June 14, 2022

**RE: Proposed Electronic Message Display (EMD) Billboard at 7440 Templeton Gap  
EPC File No. AL-21-009**

**PLOT PLAN/ SPECIAL USE MAP**  
 A PORTION OF THE NE1/4 OF SECTION 7,  
 TOWNSHIP 13 SOUTH, RANGE 65 WEST OF THE SIXTH P.M.,  
 CITY OF COLORADO SPRINGS, EL PASO COUNTY, COLORADO

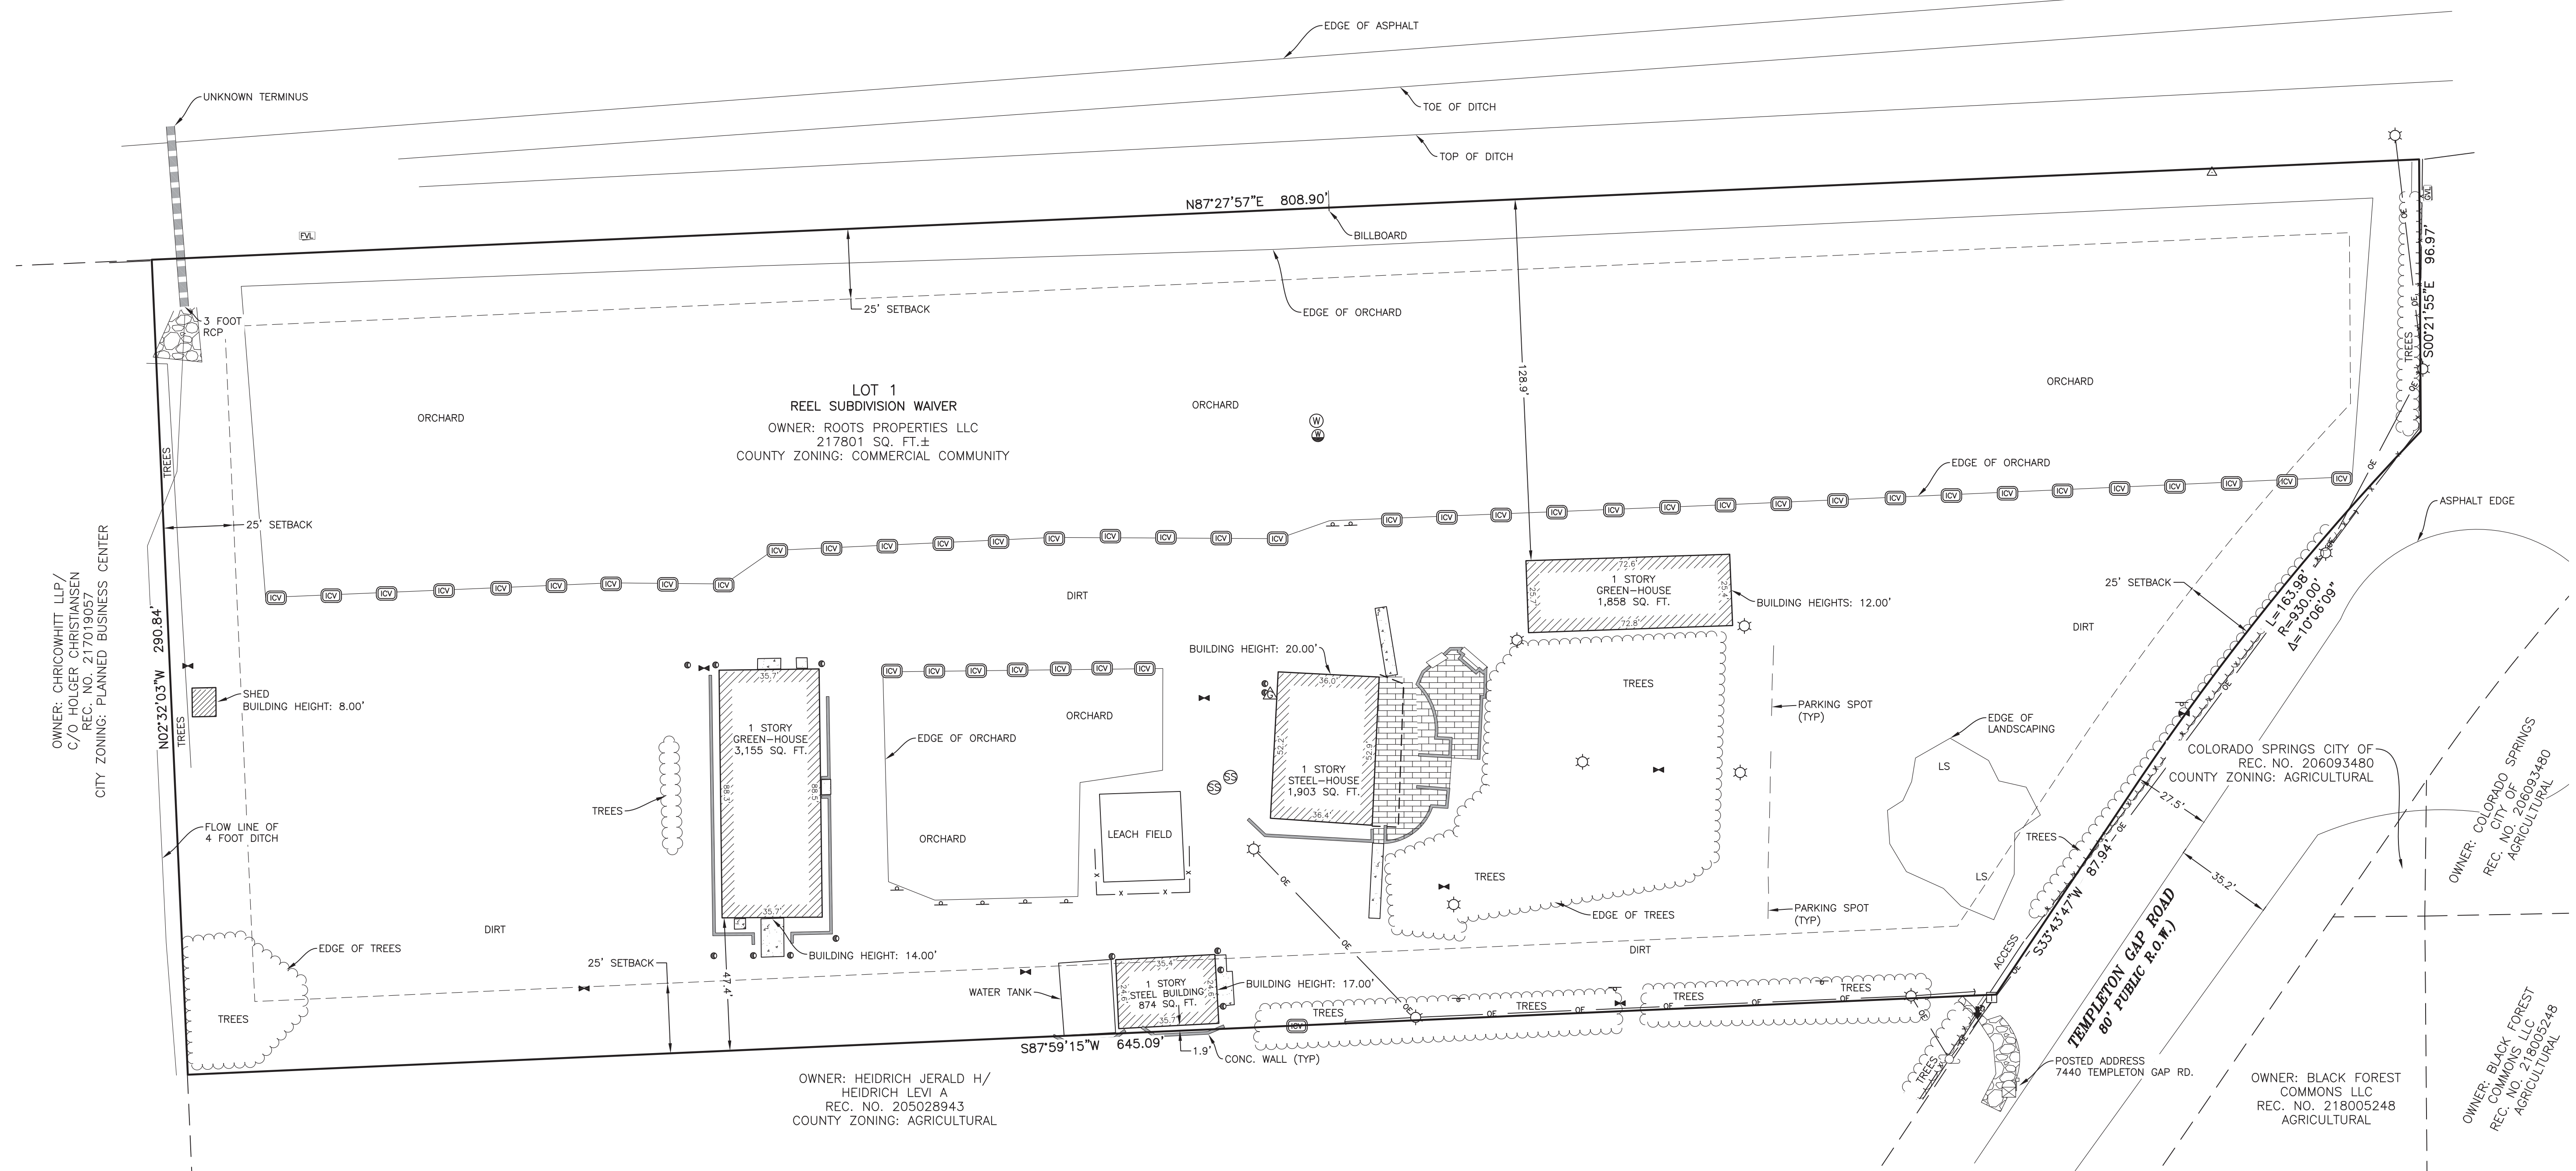
measurements from the proposed billboard which show that (a) the billboard is currently proposed to be located approximately 290 feet from the nearest point of the proposed residential building and (b) the 500 foot spacing standard reaches the center of the proposed residential building.

For these reasons, my client contends that the proposed billboard location does not meet the spacing standards set out in Chapter 6.2.9, which are intended to achieve the stated purpose of the billboard regulations to limit the impact of billboards on the community and ensure compatibility between billboards and adjacent residential land uses.

DEVELOPMENT PLAN

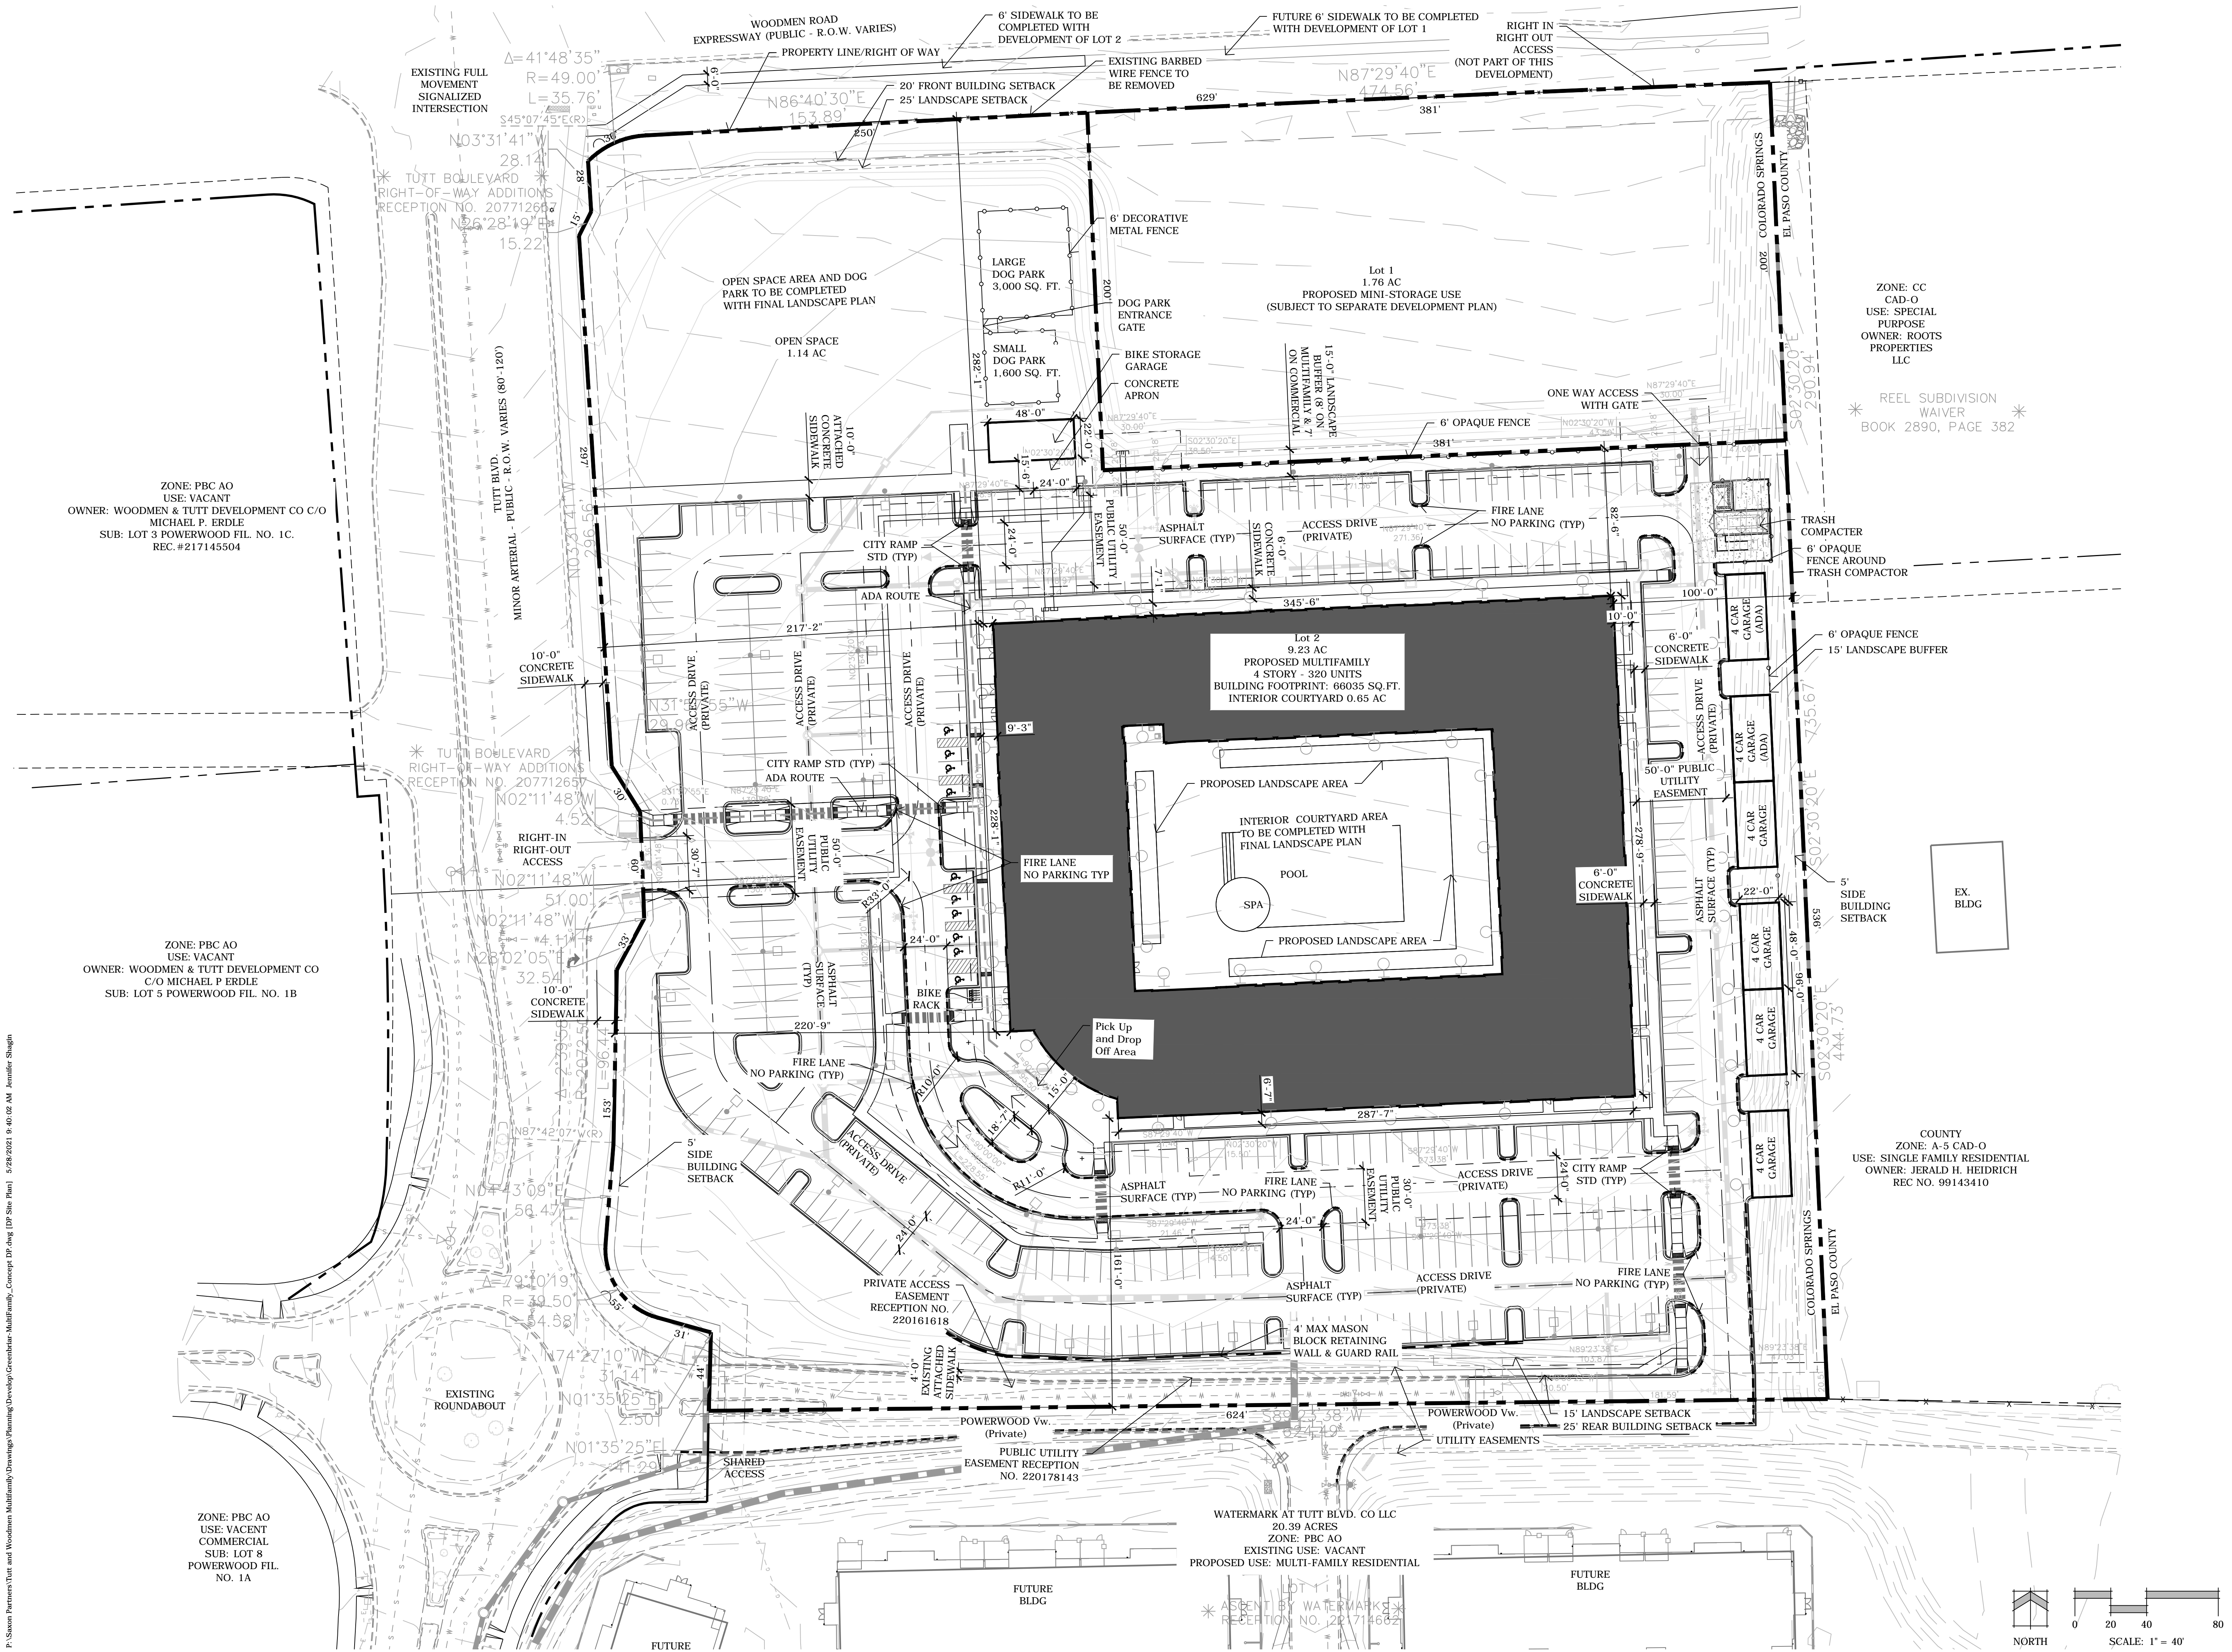
Our client’s property is zoned PBC (Planned Business Center) in the City’s Zoning Code. While this is primarily a commercial zoning district, as can be seen from the extract from the Zoning Code on page 2, all residential uses are allowed as a Conditional Use, subject to review and approval by City Planning Commission. The Conditional Use, associated Conditional Use Development Plan and Final Plat, were approved by City Planning Commission on June 17, 2021. Copies of the approved Development Plan (Exhibit A) and Record of Decision (Exhibit B) are included with this letter. An extract from the approved Site Plan is on page 2 with approximate
